DEVELOPMENT REVIEW BOARD
TRANSPORTATION DEVELOPMENT

DRB Project Number: 2021-005195
7501 Jefferson Street

SUBJECT: Site Plan

DATE: February 2, 2022

A1 SITE PLAN
 1" = 40'-0"
 0 20' 40' 80'

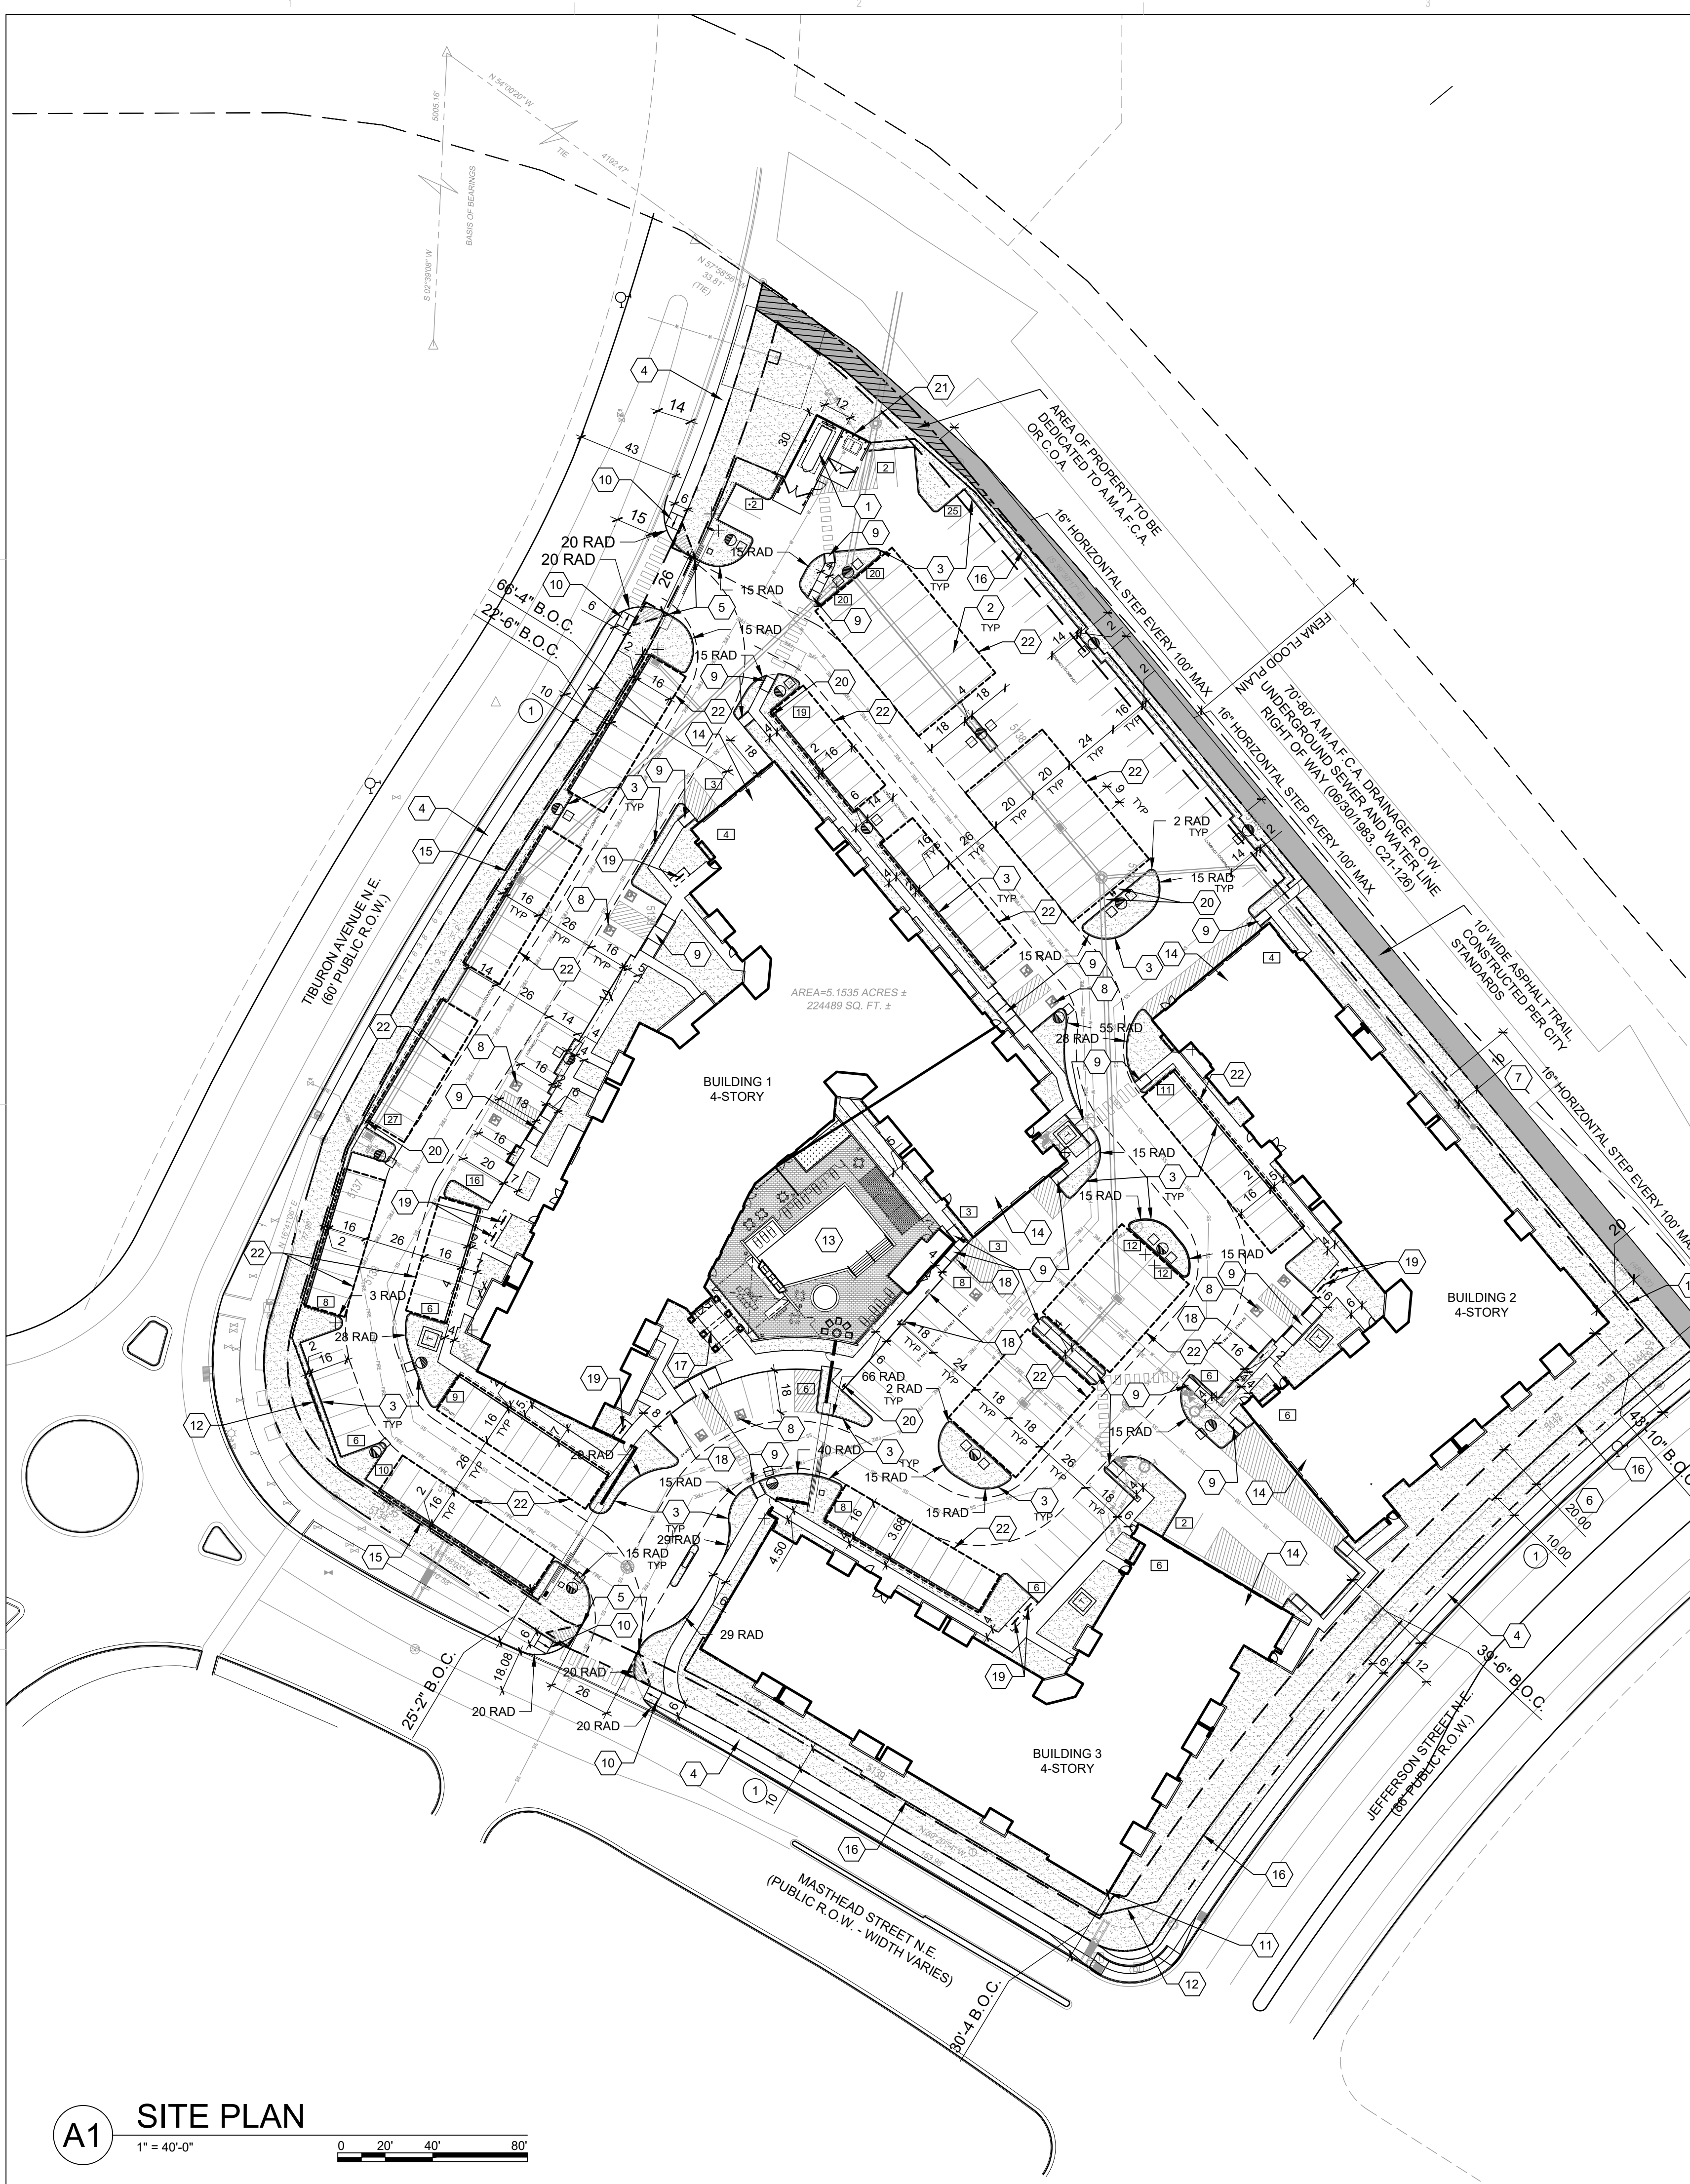
1. If the standard 18-foot parking spaces are achieved with overlap onto curb, call out the overlap to show that it meets the minimum standard with a keyed note. (There is a dashed line that is 2 feet from the curb which looks like it represents the overlap.)

2. For Note 19 at each of the bike rack locations, call out the number of bike racks that matches the number under the parking calculations.
3. New sidewalk construction shall be part of a work order; place onto an infrastructure list. Length of sidewalk meets criteria for work order. The wrong reference is shown for the curb ramps within the COA right-of-way.

6. Due to speeds on surrounding streets, call out clear sight triangles on both the site plan and on the landscaping plan due to intersection sight distance.

C1 SECTION @ JEFFERSON
1/8" = 1'-0"

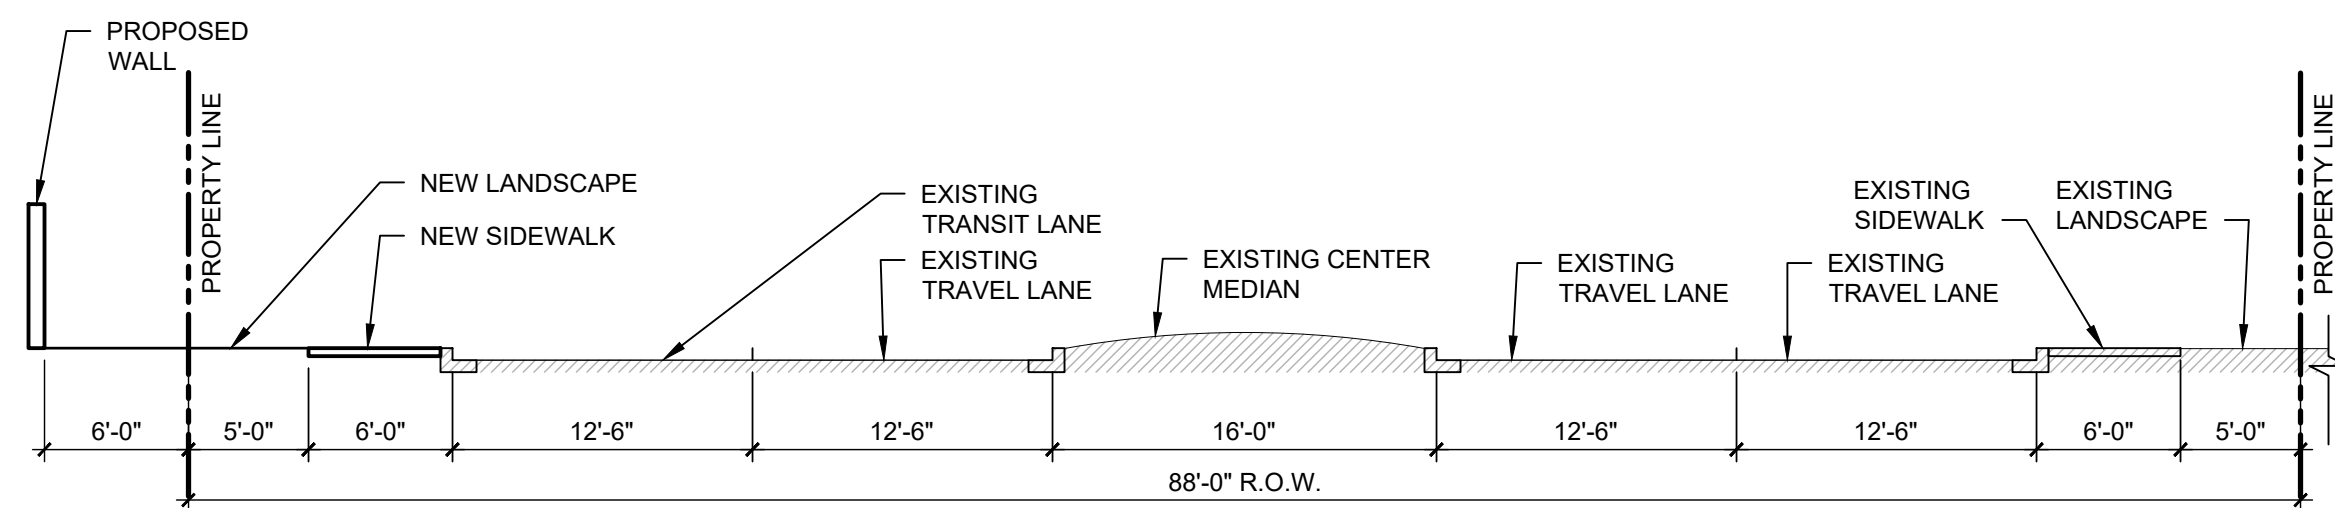
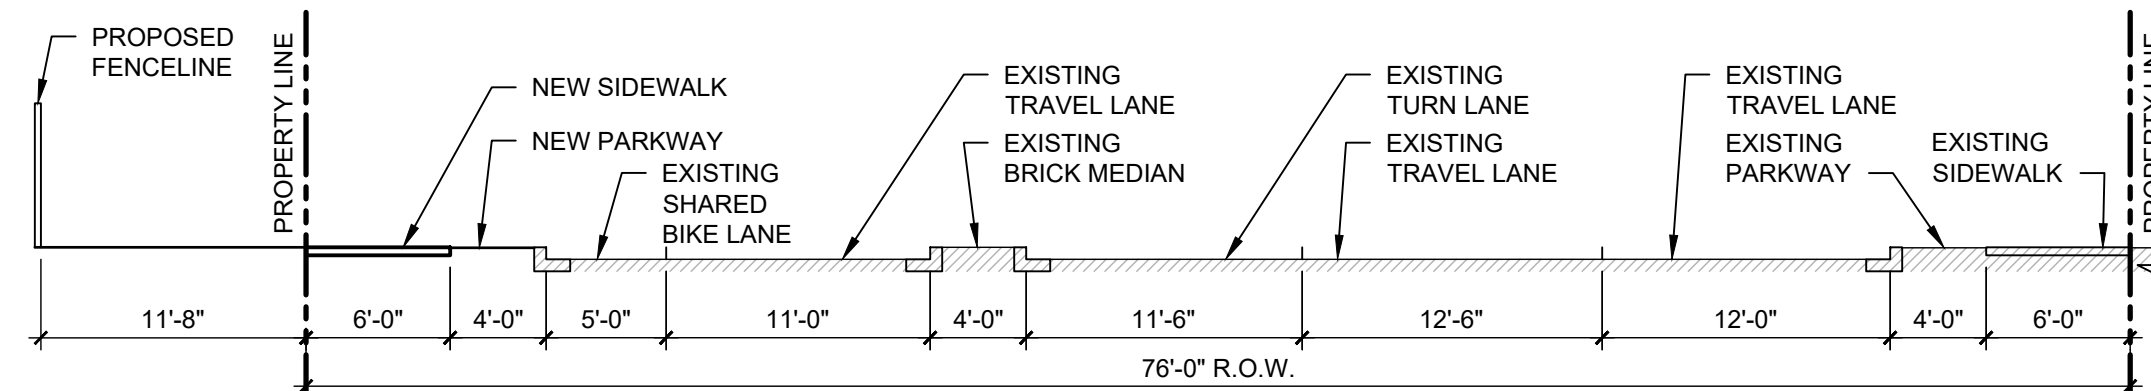
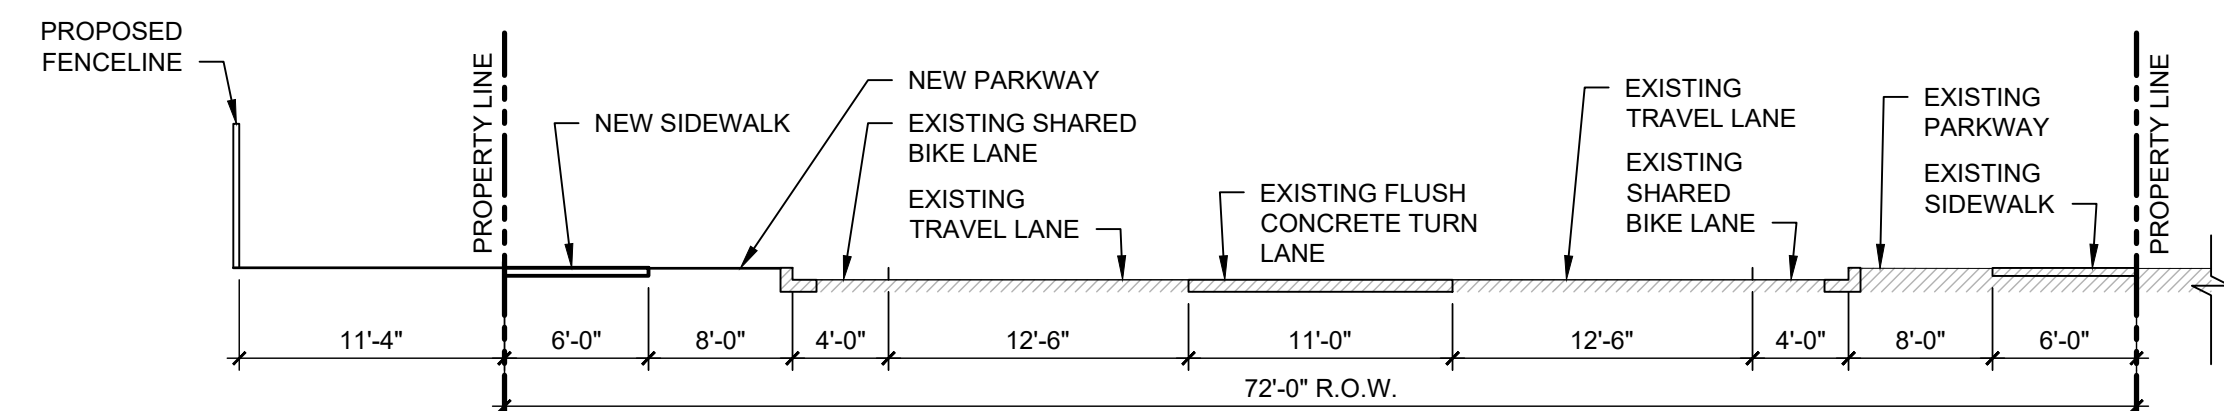
4. Attach Fire-1 Plan if obtained.
5. Bike lane markings are required on Tiburon Street and Masthead. On a cross-section for each road, indicate these proposed facilities while following guidelines to terminate markings in advance of the roundabout. On Jefferson Street, make sure sufficient space is given to bike lane facilities for future development, and provide a cross-section; it was decided previously to dedicate right-of-way for future purposes.
